Re: **Popeyes Juan Tabo**
840 Juan Tabo Blvd NE
Traffic Circulation Layout
Engineer's/Architect's Stamp 9-13-24 (K22D035A)

Based upon the information provided in your submittal received 10-2-24, the above referenced plan cannot be approved for Building Permit until the following comments are addressed:

Sheet: C701

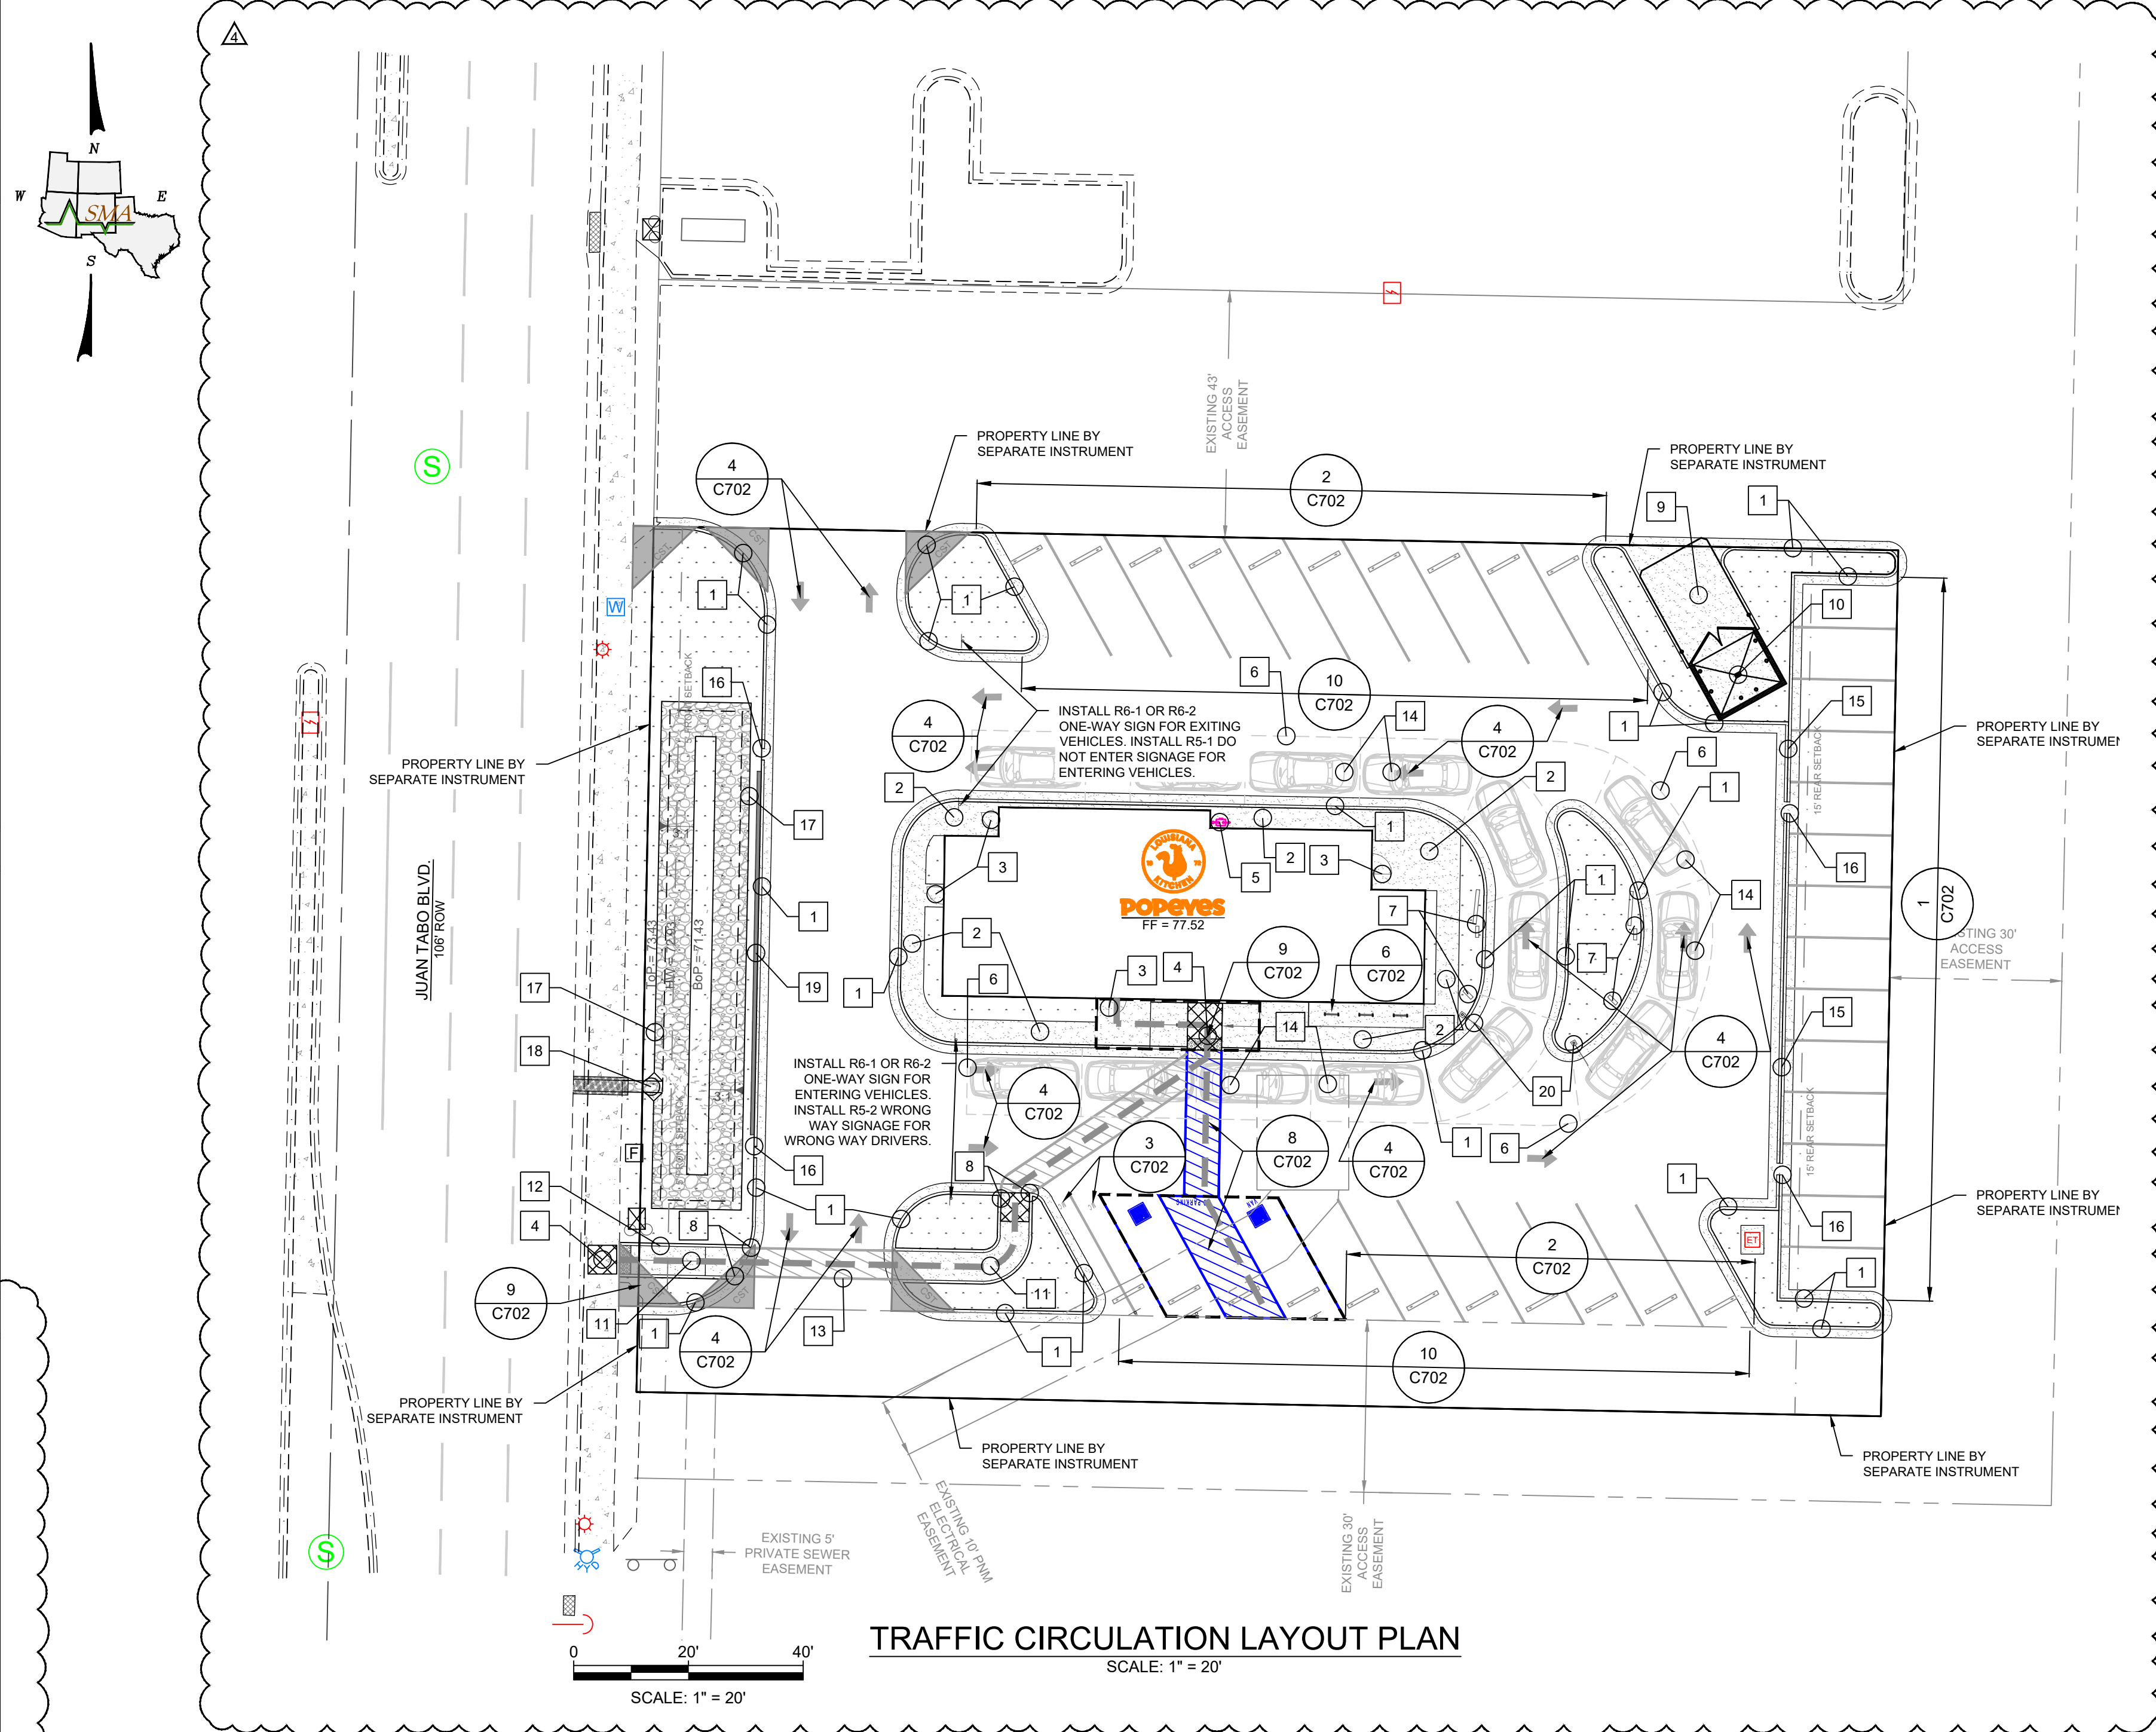
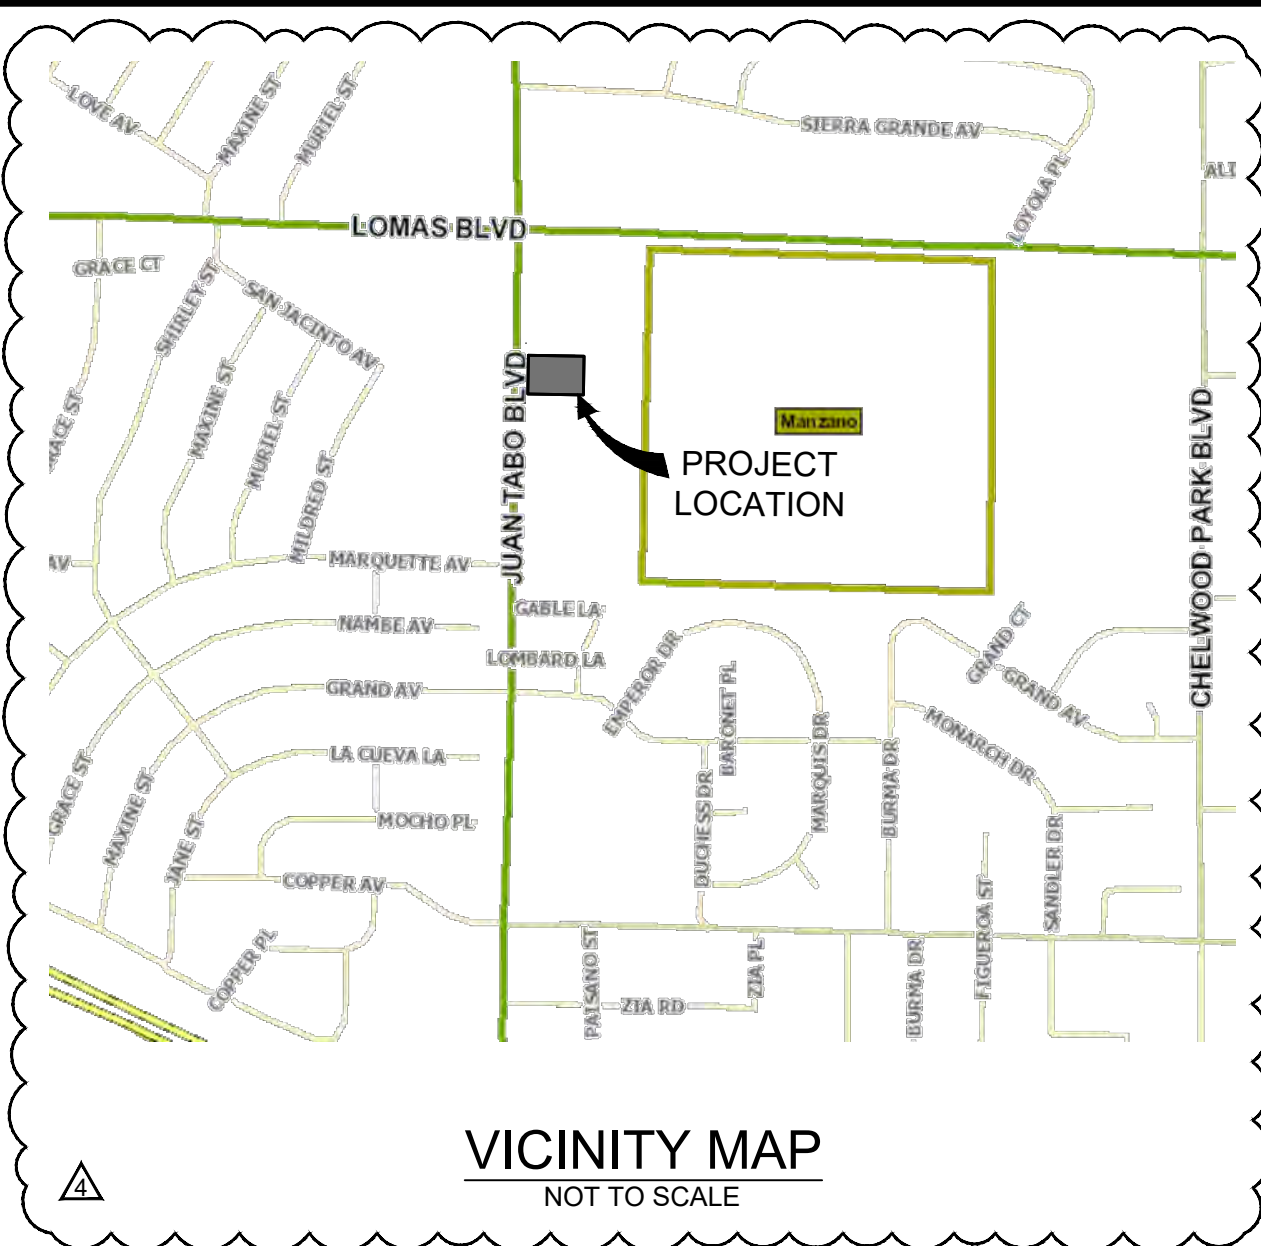
1. Please show a vicinity map showing the location of the development in relation to streets and well known landmarks. **SMA has added vicinity map to TCL sheet C701.**
2. Show all the dimensions for the entrances/exits, drive aisles and any other missing dimensions. **SMA will include dimensional site plan in TCL submittal.**
3. Please list the width and length for all existing and proposed parking spaces. Some dimensions are not shown. **SMA will include dimensional site plan in TCL submittal.**
4. A 1-foot clear zone around the bicycle parking stall shall be provided. **SMA has adjusted the bike parking detail on sheet C702.**

5. Per DPM, a 6 ft. wide ADA accessible pedestrian pathway is required from the ADA parking stall access aisles to the building entrances. Please revise the width to 6' (keyed notes 12 and 13). **SMA has updated the access aisle to 6' on all sheets.**
6. All one-way drives shall have "One Way" and "Do Not Enter" signage and pavement markings. Please show detail and location of posted signs and striping. **SMA included details and signage for one way drive aisles on the TCL.**
7. The minimum drive through lane width is 12 feet with a 25 foot minimum radius (inside edge) for all turns. (A 15 foot radius can be used with an increase in lane width to 14 feet). Please dimension all lane widths and radii. **SMA has adjusted the site plan accordingly, please see dimensional site plan for dimensions.**

8. Show the clear sight triangle and add the following note to the plan: "Landscaping and signage will not interfere with clear sight requirements. Therefore, signs, walls, trees, and shrubbery between 3 and 8 feet tall (as measured from the gutter pan) will not be acceptable in the clear sight triangle. **SMA has added the CST and note to the TCL.**

9. Add a note stating "All broken or cracked sidewalk must be replaced with sidewalk and curb & gutter." **SMA has added the note to the TCL.**
10. Show the existing sidewalk and buffer/landscape widths along Joan Tabo. **SMA will include dimensional site plan in TCL submittal.**

11. Relocate the parking blocks (Stops) by 60 deg angle and 2' away from end of the parking stall. Add parking blocks (Stops) for the north side parking stalls. **SMA has adjusted/added the concrete bumpers on the TCL.**
